Ribble Valley Borough Council  
By email

Your ref: 3/2023/0812  
Our ref: DC/23/3762v2  
Date: 21-DEC-23

**Location: Old Row Whalley Road, Barrow, BB7 9AZ.**

**Proposal: Approval of details reserved by conditions 5 (surface water drainage).**

Drawn	Date	Checked	Date	Approved	Date
MH	May 23	MS	May 23		
Scale	1:250	Orig Size	A1	Dimensions	
Project No.	882667	Drawing File			
Drawing No.	10-01			Rev.	P4

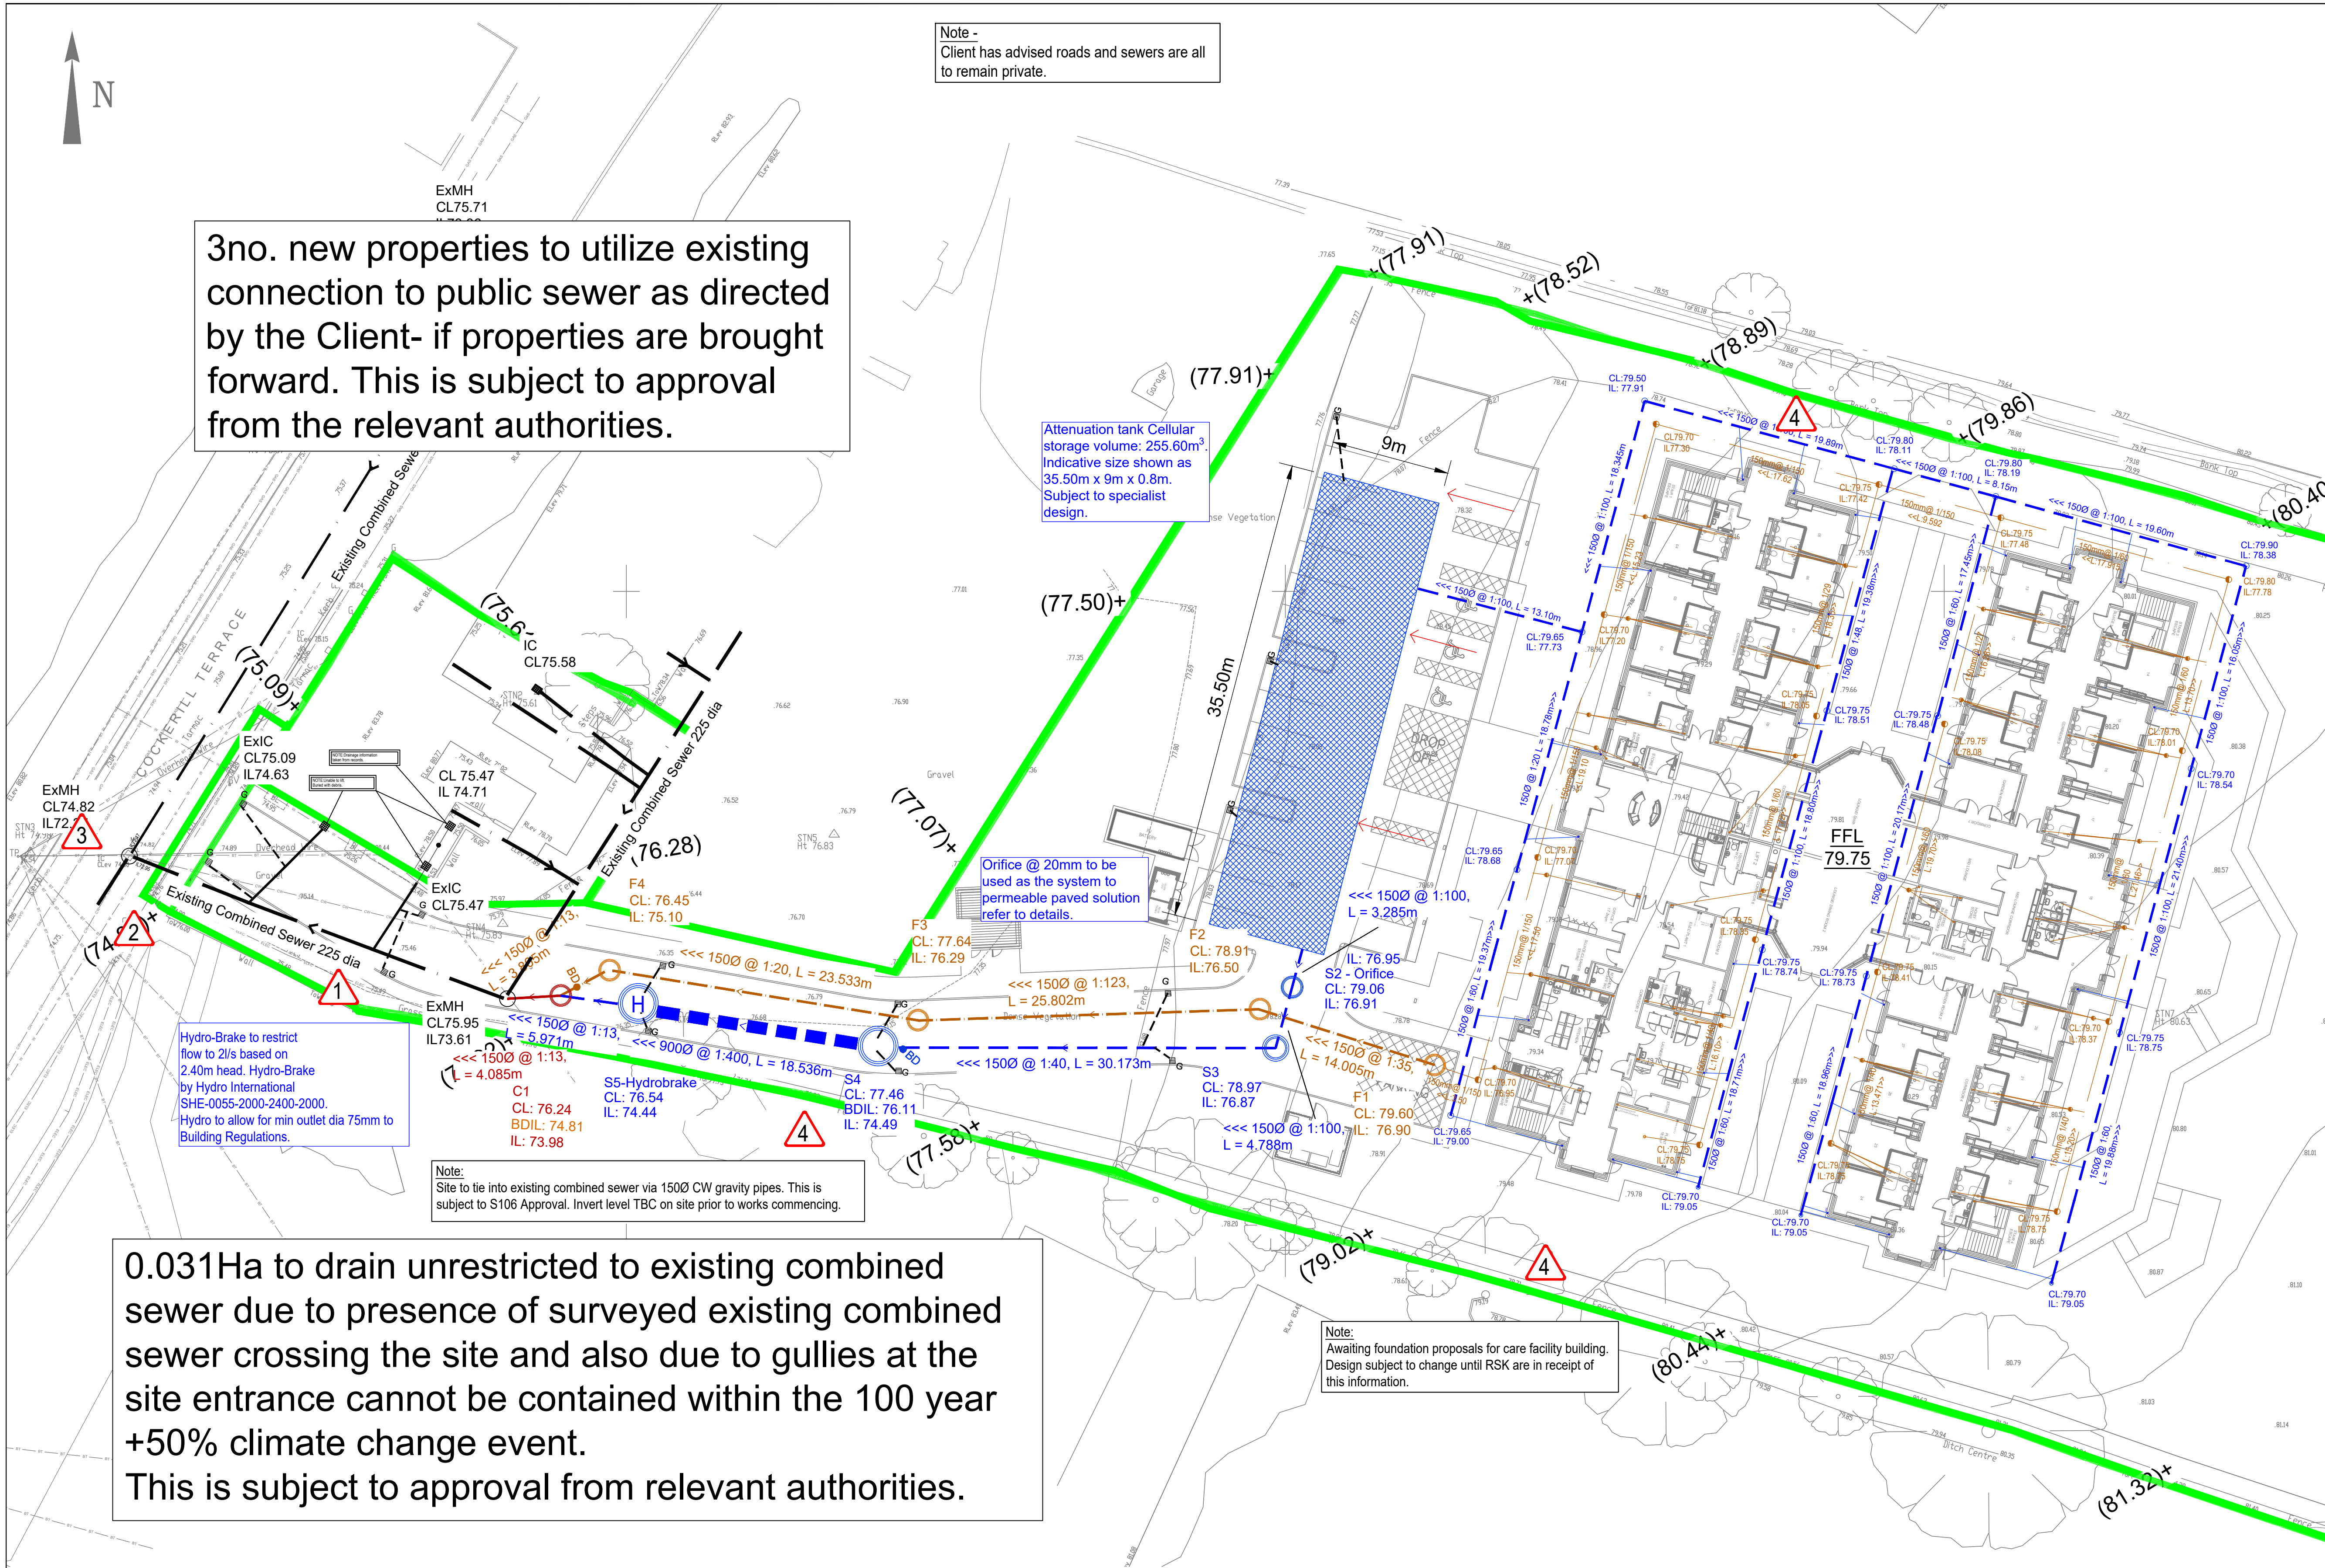
Further to our review of the submitted documents, Drawing 10-01, Rev P4 - Dated 10.10.23 and Calculations Detailed Design Storm Network 1, LDE Wigan3.

United Utilities recommends that condition 5 is not discharged.

This is because United Utilities finds insufficient justification and information from the Parish Council for the surface water to not go to the watercourse.
